CCSN Comments

Rehabilitation Strategy PA 06_0295

Doc N° 710 - 005-EN-STR-00XX

Rehabilitation strategy required within 3 months of Mod 14 Project Approval dated November 2021 (Condition 36 and Schedule 3).

Figure 6.1: CVO Rehabilitation and Woodland Enhancement

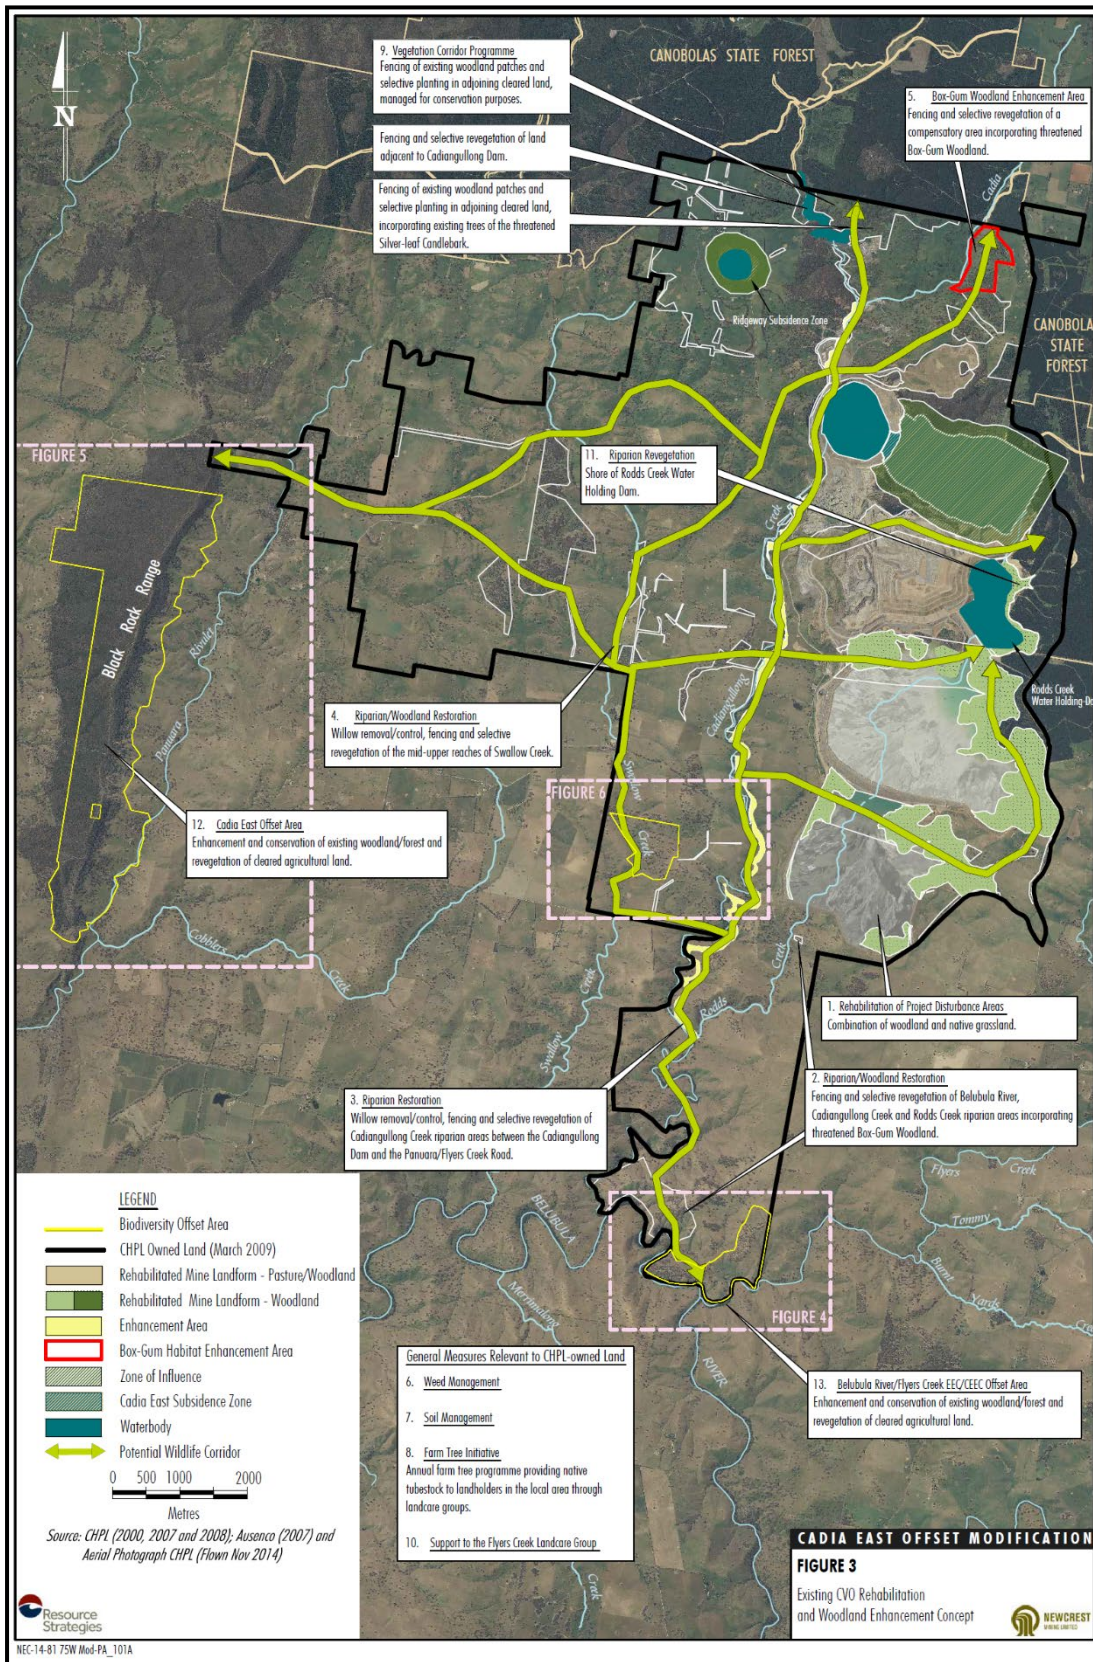
The conceptual final land form and rehabilitation plan presented in 3-1, 2 & 3 is completely different to Mod 14 fig 6.1A Land Form for NTSF and STSF. Drainage appears to be via Rodds Creek meandering through both tailings storage facilities. This would require water to flow uphill and result in a significant waterfall at Panuara Road. This is obviously a mistake.
